**WEST SUSSEX COUNTY COUNCIL
STRATEGIC PLANNING CONSULTATION**

SUBJECT: A/114/17 – Hangleton lane – Highway outside Hangleton Nursery

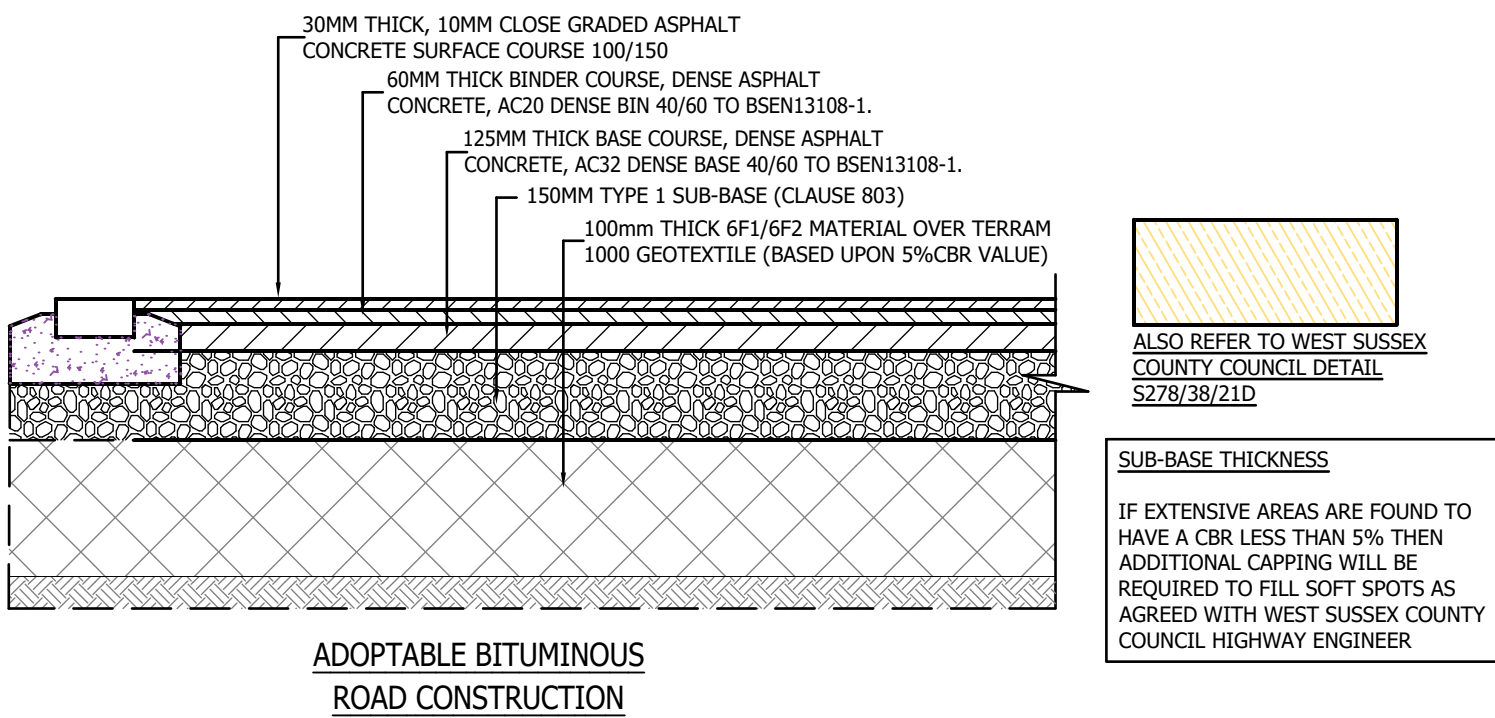
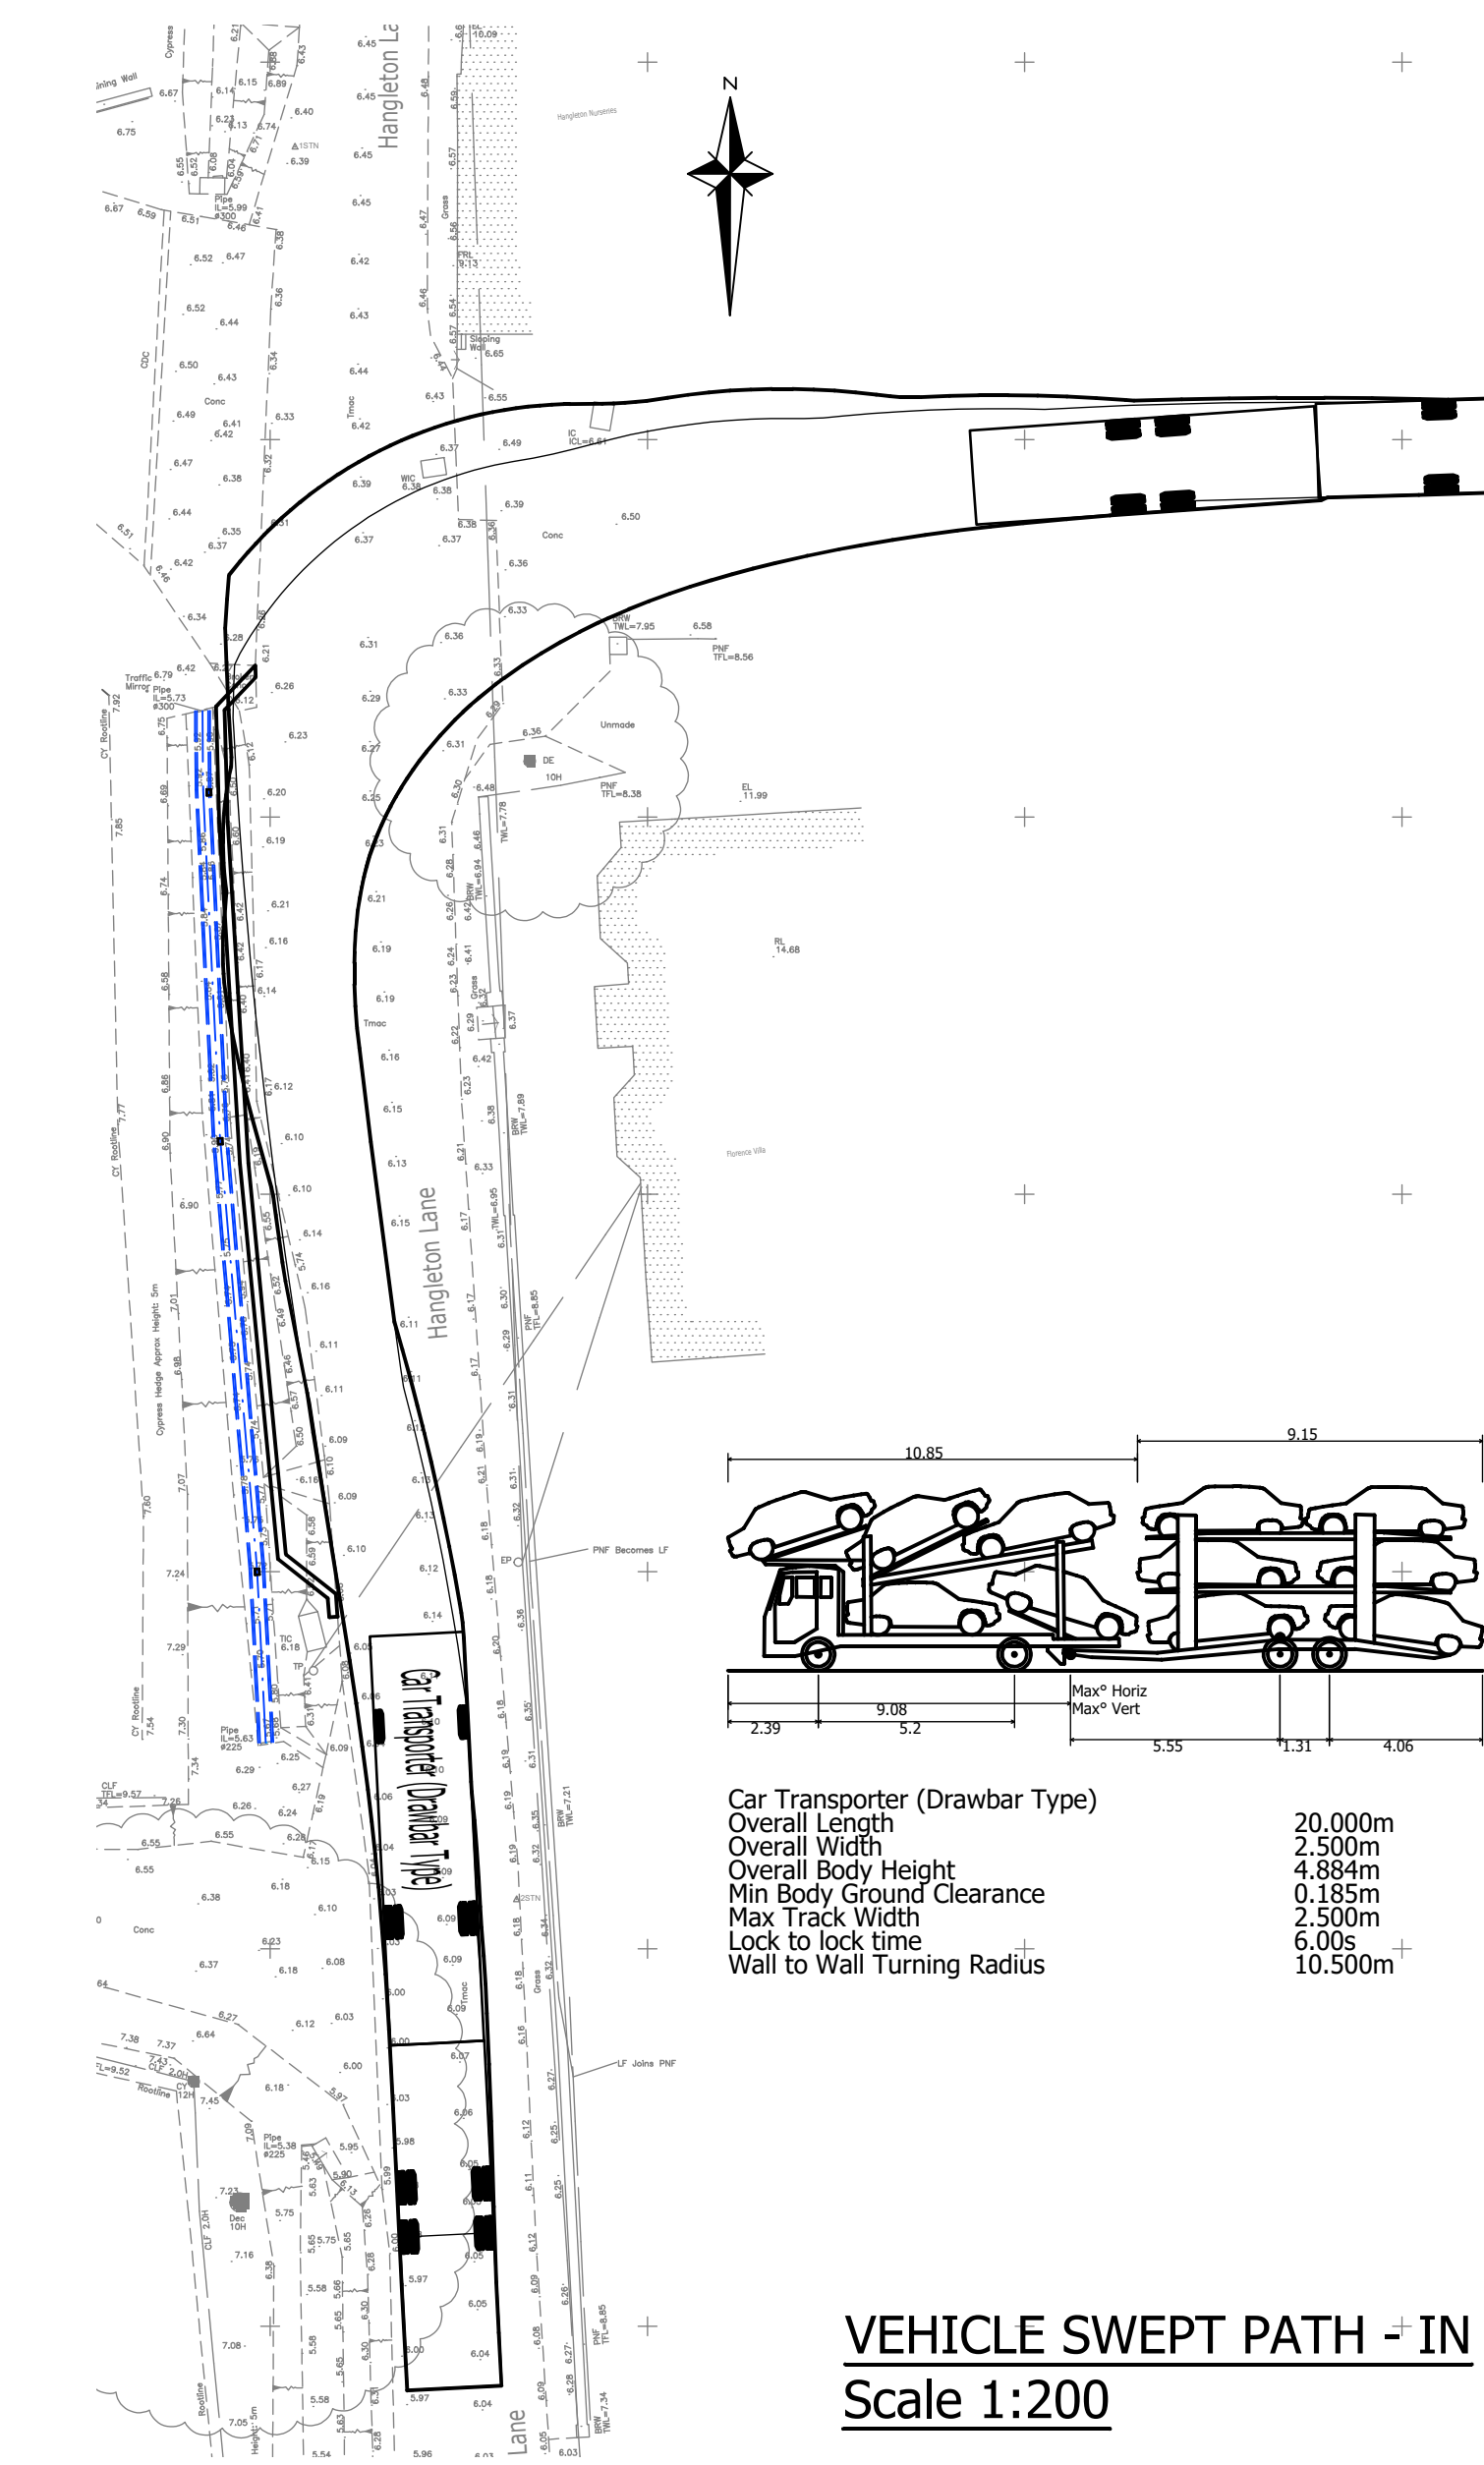
- 1) The designer should consider the risk that the widening will be misused as a parking area, thus making it more difficult for his client to access the land.
- 2) The northern tie-in need not affect the concrete apron serving the crossover to the Cobbins Nursery greenhouses to the west.
- 3) The lane is extremely narrow. Are passing places required? Is this associated with an intensification of use?
- 4) The road makeup will be reviewed as part of the S278 application review process.
- 5) Suitable visibility splays for the site access and for the crossover to the Cobbins Nursery greenhouses to the west shall be shown on the drawing.
- 6) It is not clear from the drawing whether the ditch is highway land or under private control. I have looked at our mapping data and it is still unclear to me. I have asked WSCC Landcharges to look into this.

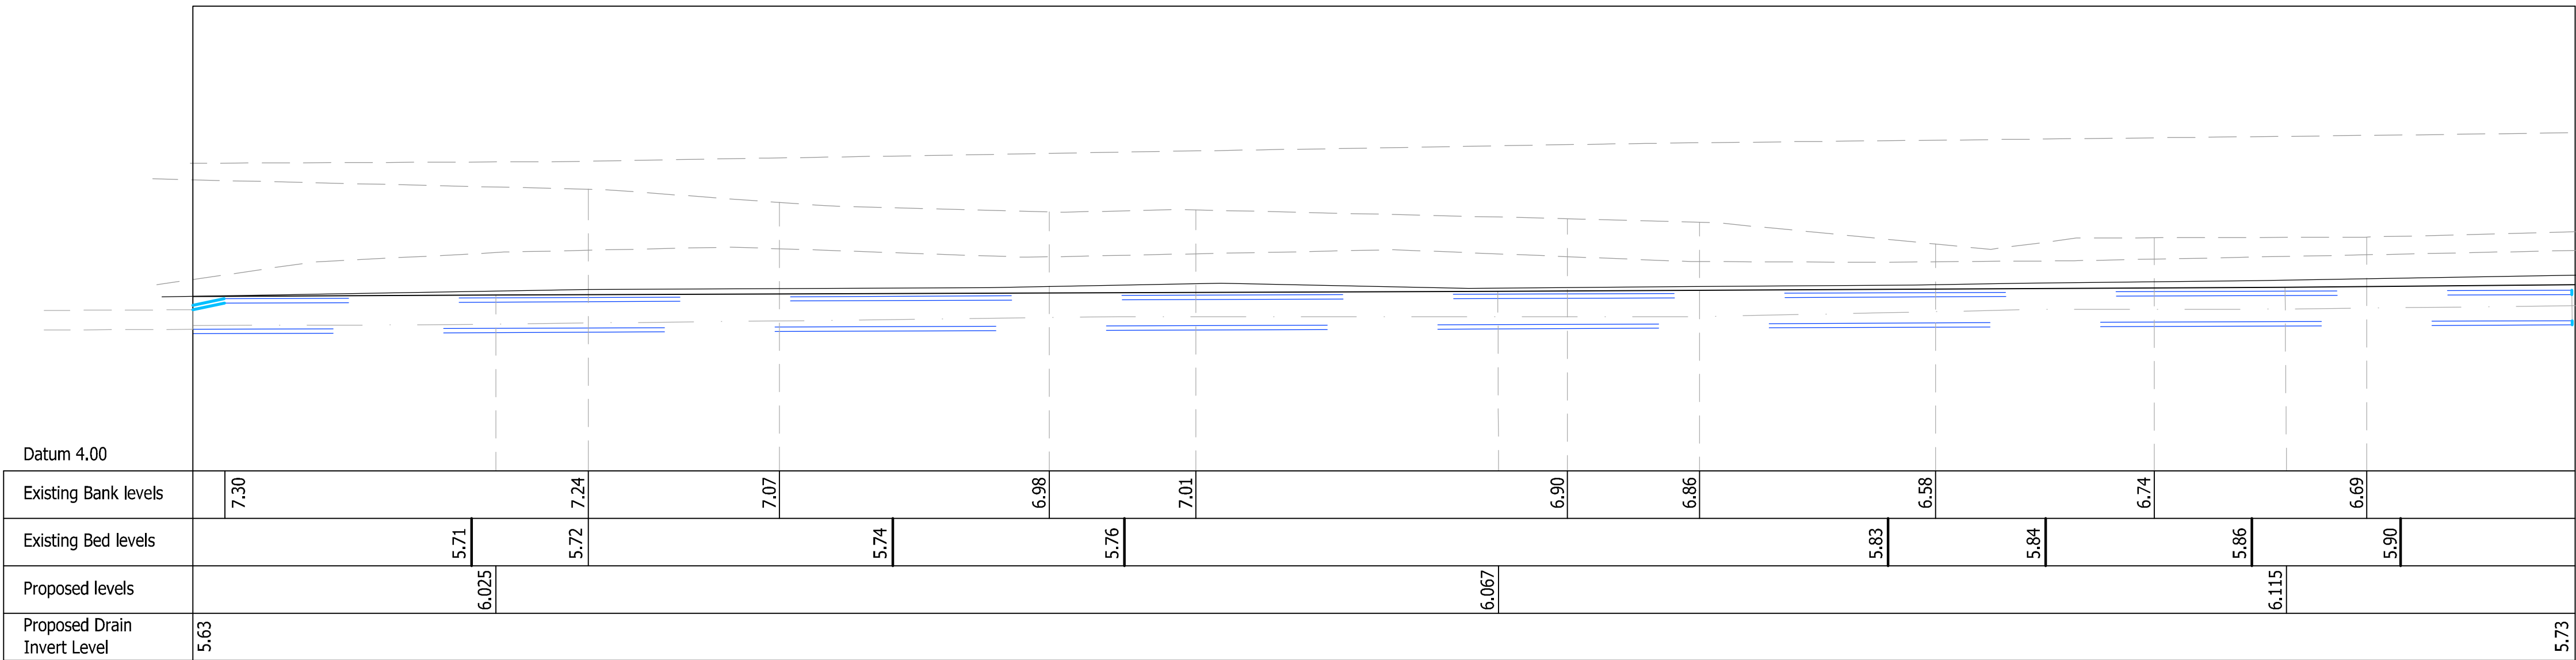
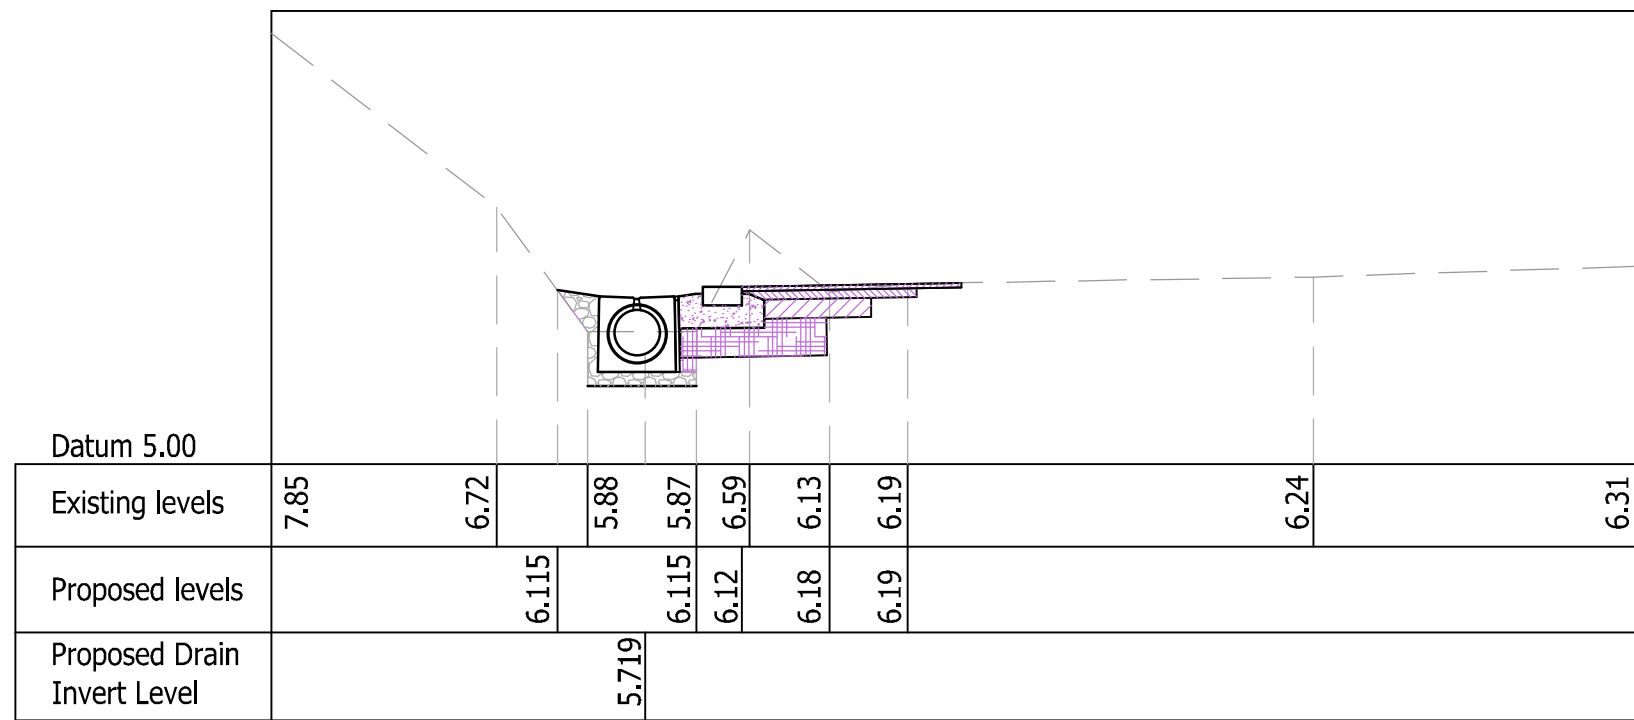
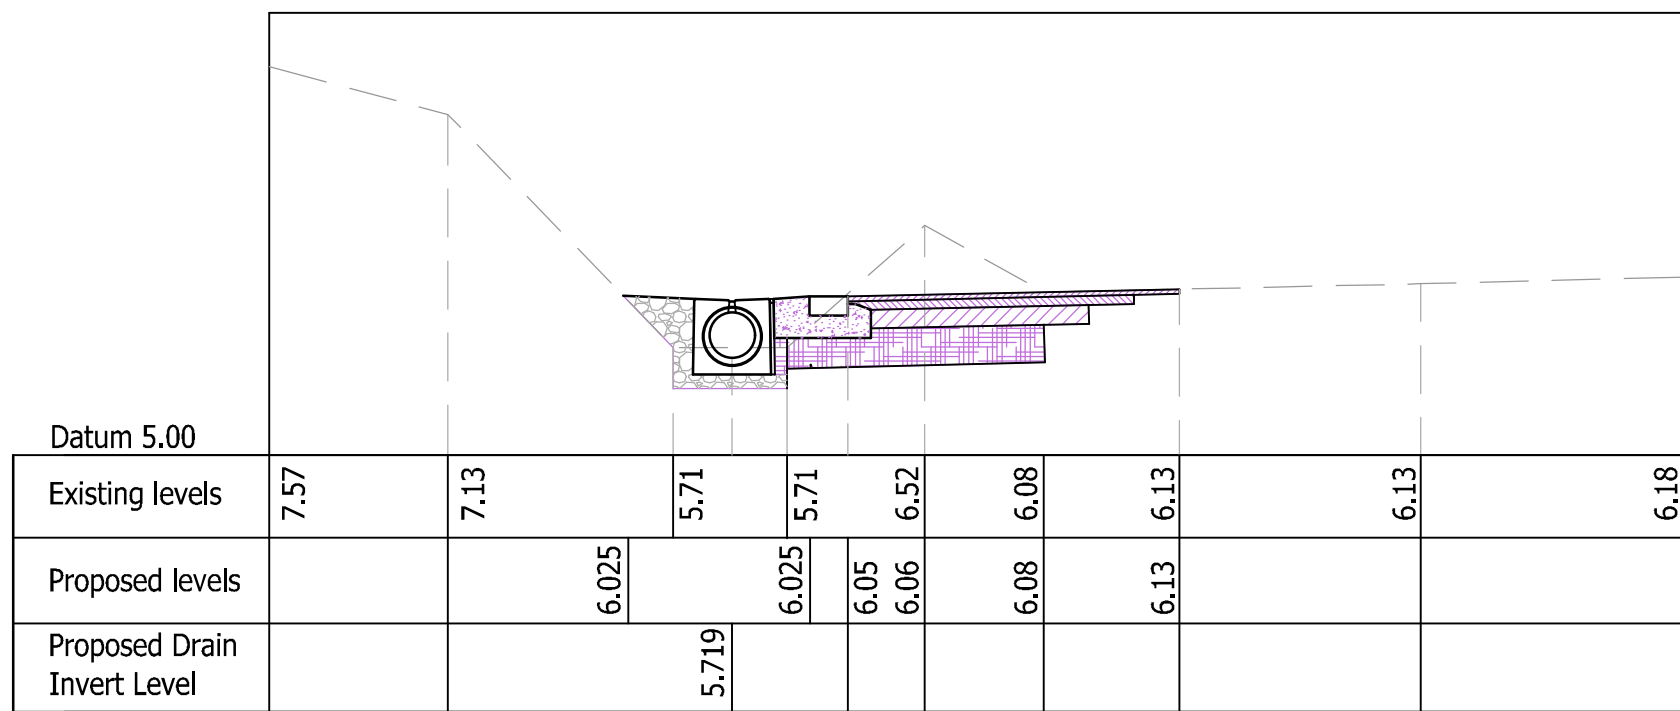
Drainage Strategy/Existing Watercourse

1. The existing watercourse and culverts appear to flow southerly towards the A259.
2. The existing watercourse cross sectional area would appear to be significantly diminished by the culvert proposal.

10. It is evident that the majority of Hangleton Lane appears to drain 'over the edge' either side and there are a few loosely define grips allowing run-off to the watercourse.
11. On review of section AA & BB it is evident that the eastern channel verge is elevated above the highway. These verge and bank areas would naturally attenuate flows and collect silts, and provide a reasonable level of pollutant control.
12. The post development proposals provide no evidence of siltation control or pollution control.

13. The existing watercourse is currently easily maintainable and blockages/issues would be visually identified.
14. The post development solution offers no access points or sumps.

15. WSCC operate an open ditch policy where watercourse can be retained or diverted opposed to culverting.
16. Any works affecting a highway ditch or ordinary watercourse must be first approved under a Land Drainage Consent to enable the shared views of the LPA.
17. WSCC follow the historic EA rule of thumb whereby any culverting shall be a minimum 450mm diameter pipe or larger, unless otherwise constraint.

18. The loss of watercourse storage and increase in catchment area will need to be considered.
19. Subject to determining the available development land, we consider it preferable to retain the ditch and install a new vertical wall and/or upstand kerb feature.
